Application No: LU/247/20/PL
Site Address: 57 River Road Littlehampton BN17 5DD
Description of works: Partial demolition of existing building, retention of boundary wall & street facade, partial demolition of boundary wall to incorporate new pedestrian gateway & gate, erection of 6 No. flats in 2 blocks connected by shared stair & lift core, on site parking yard for 8 No. cars & 8 No. cycles & space for communal refuse & recycling bins. This application affects the character & appearance of the Littlehampton River Road Conservation Area & is in CIL Zone 4 (Zero Rated) as flats.

Thank you for your internet representation made on 18th October 2020 which has been recorded as no objection with the comments as follows:

Although The Littlehampton Society does not object to the proposed new buildings (subject to the comments below), we are very concerned that the heritage of the existing building should be carefully considered and make the following comments :

TITLE: PROPOSED DEMOLITION PLAN

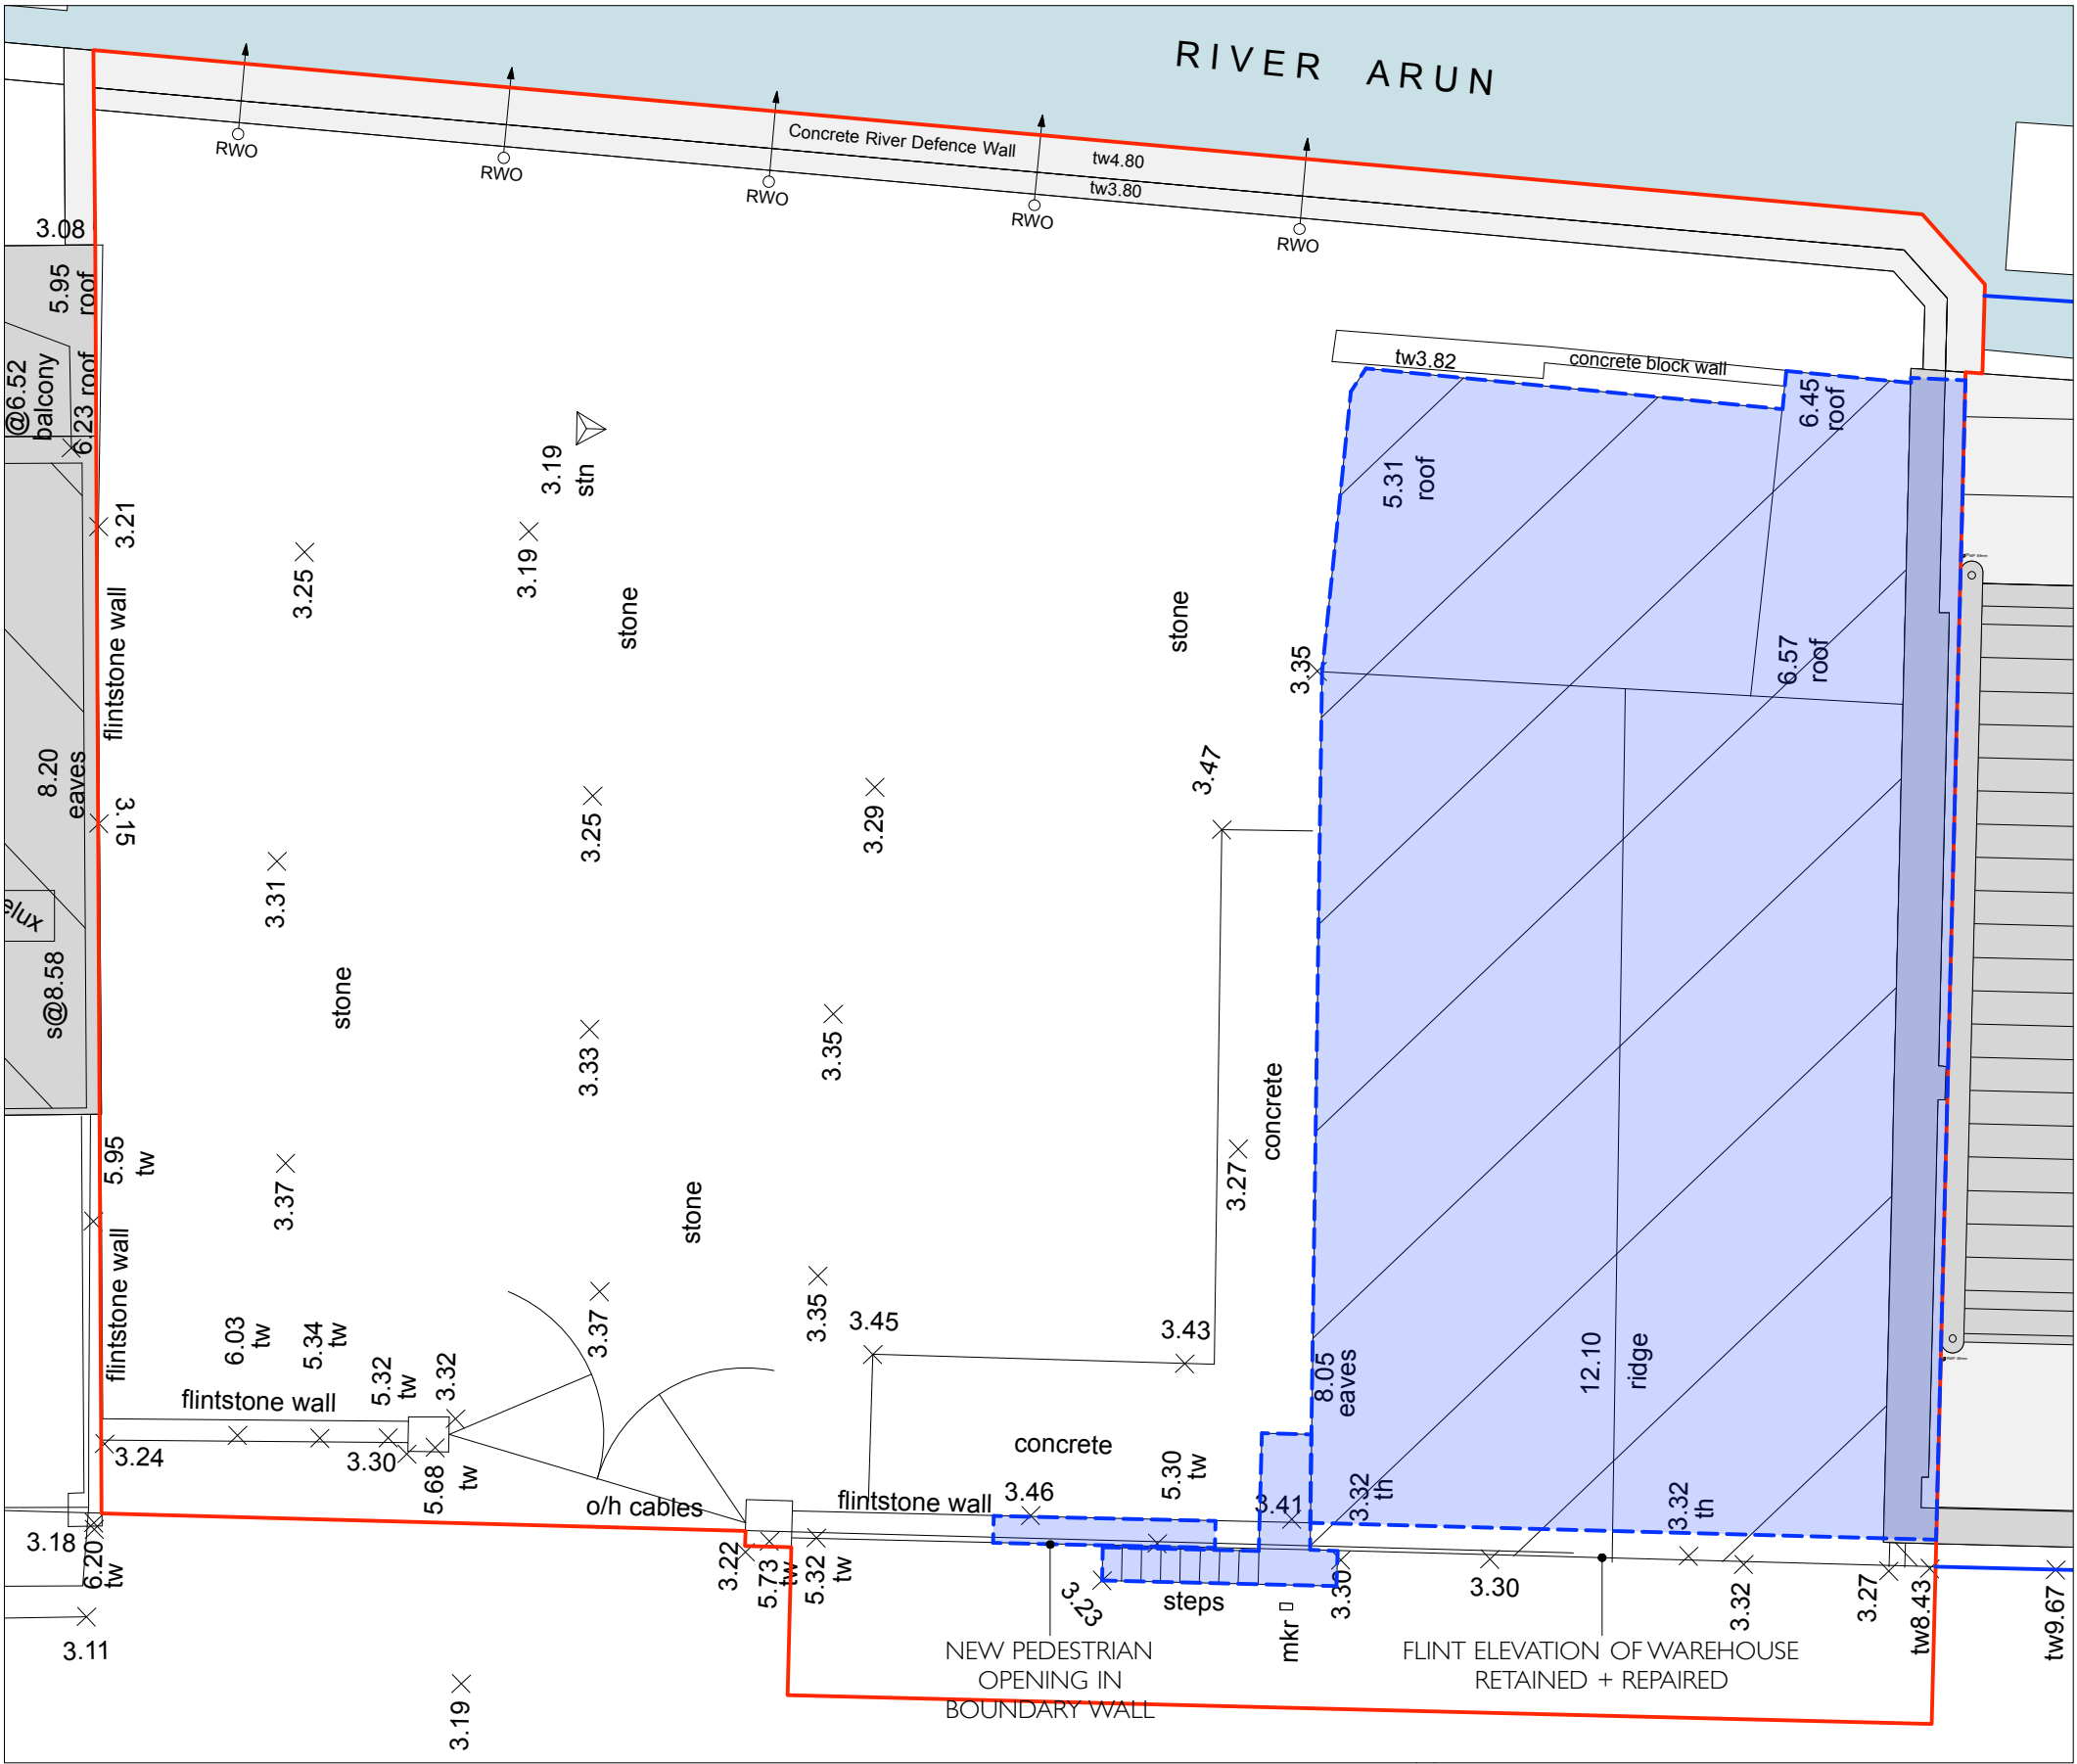
2. Given the high local heritage value of the building and its need to be considered as a non-designated heritage asset, every attempt should be made to retain it without substantial removal of historic fabric. The condition report submitted with the application does not indicate that the building is in poor structural or dangerous condition and the issue surrounds the viability of finding uses for the building given the costs of repair. In coming to a view that the substantial demolition of the building should be permitted, the Council needs to be fully satisfied that there is no viable appropriate use for the
